Our Ref: AB/121/12/L

Planning (Listed Buildings and Conservation Areas) Act 1990 (as amended)
Planning (Listed Buildings and Conservation Areas) Regulations 1990 (as amended)
Application for Listed Building Consent

Development Application for listed building consent for 1 No new dwelling
Location Land adjacent to 84 Maltravers Street Arundel

Location & Block Plan

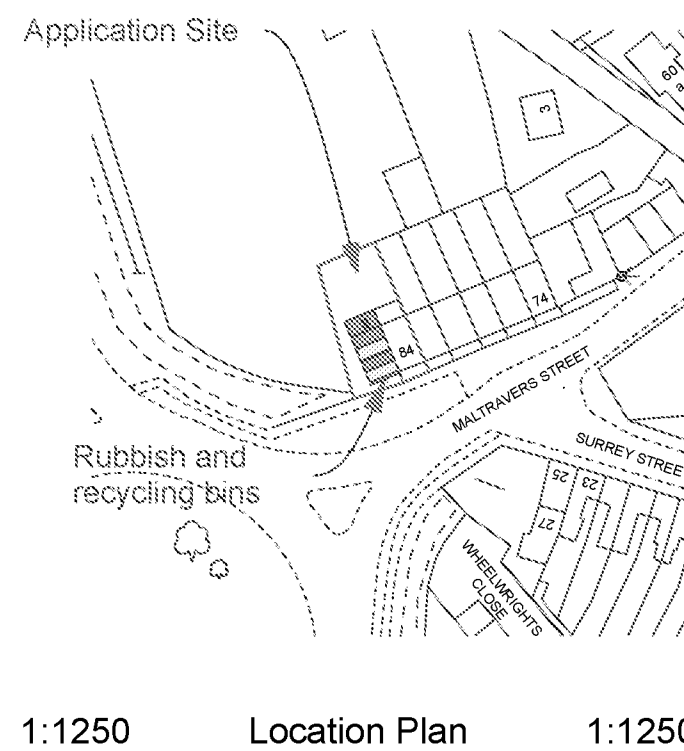
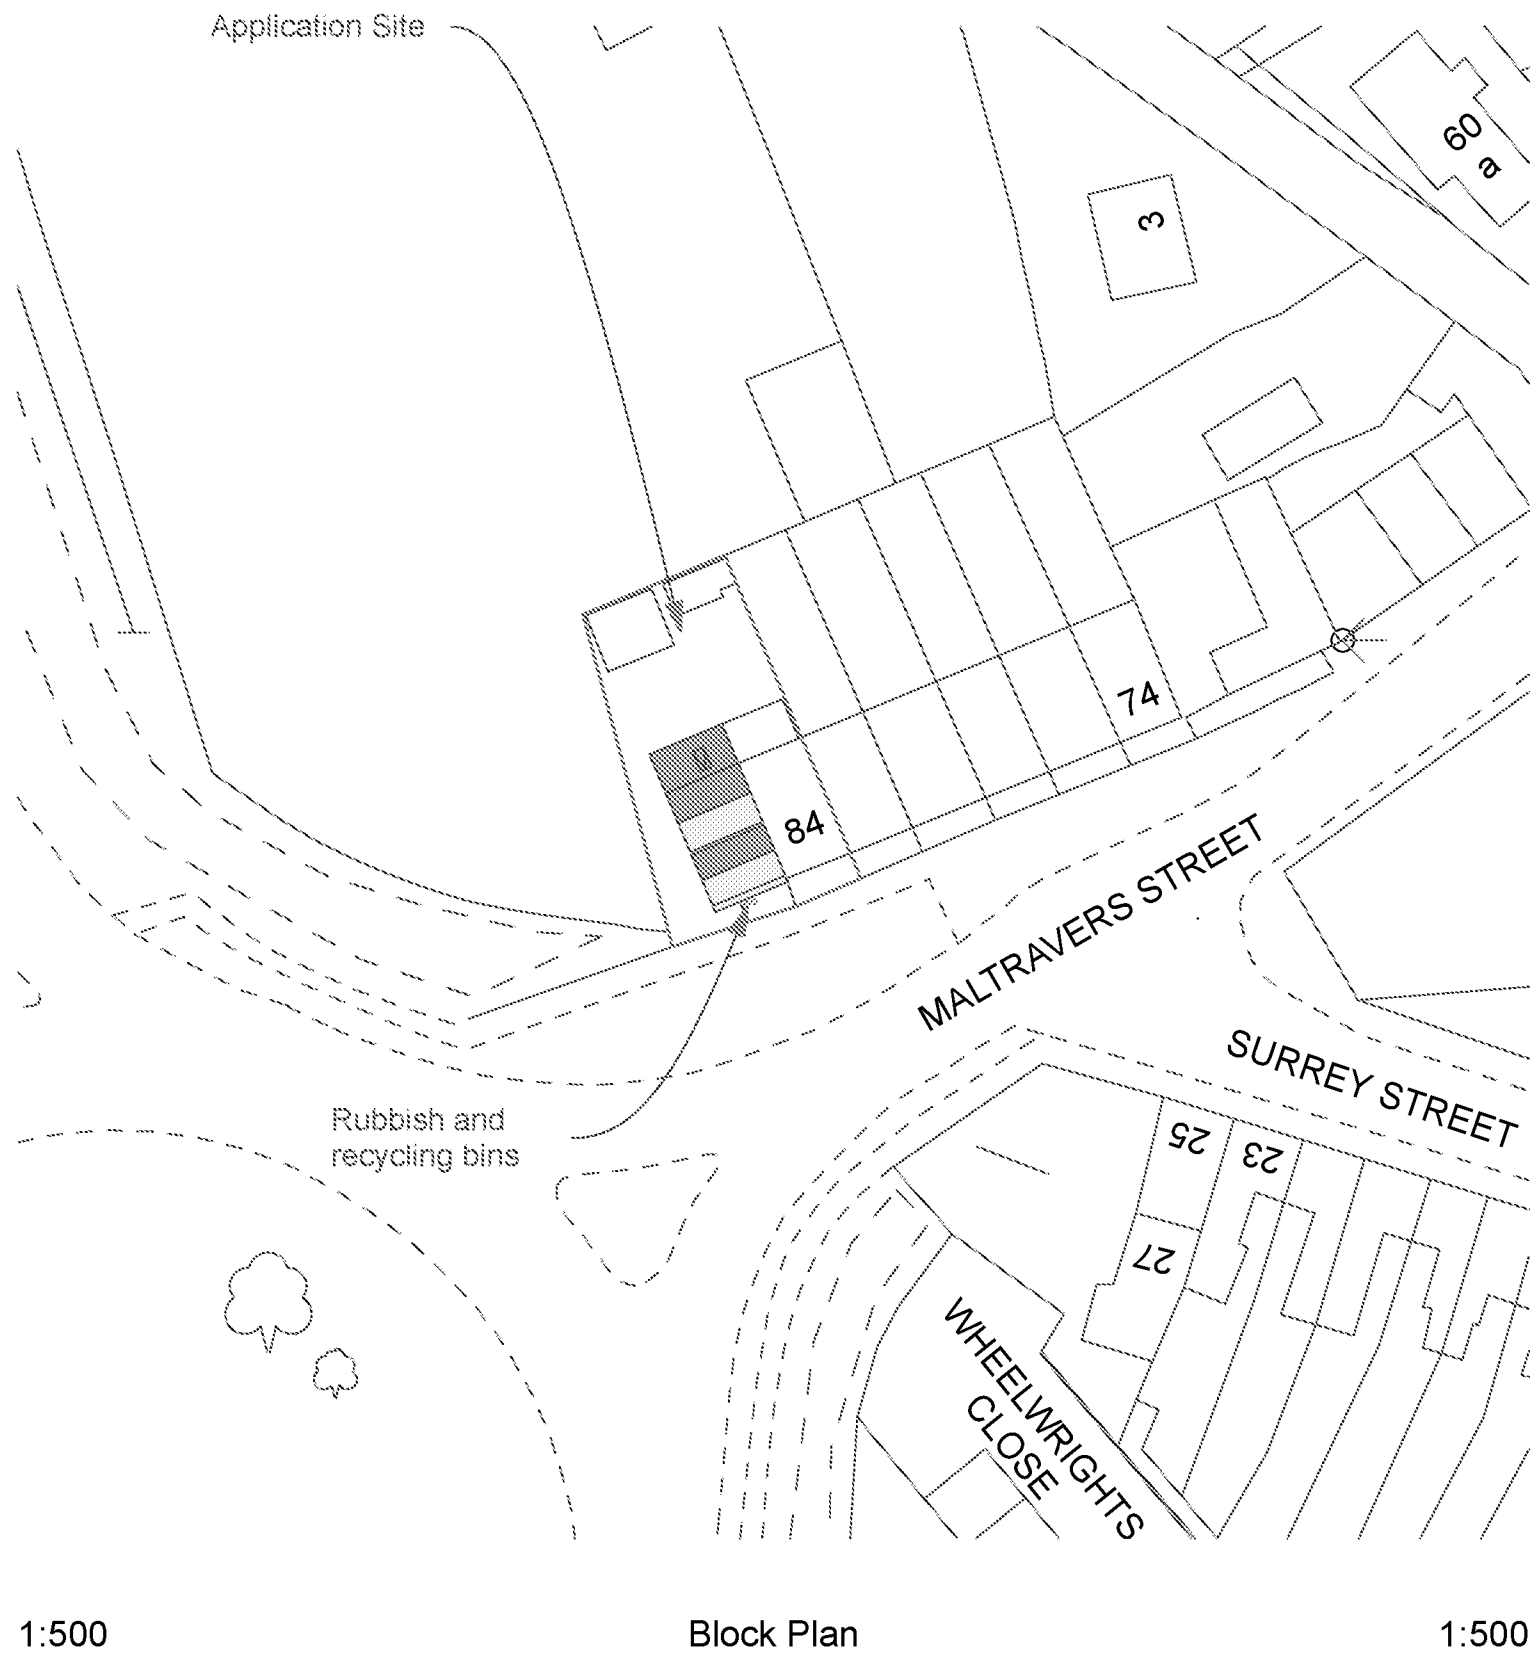
Please submit 1 electronic or 3 paper copies of a block/site plan in accordance with the guidance notes available on our website detailed below (click on National List). Please show the position of the rubbish and recycling bins. ✓ 9/11/12
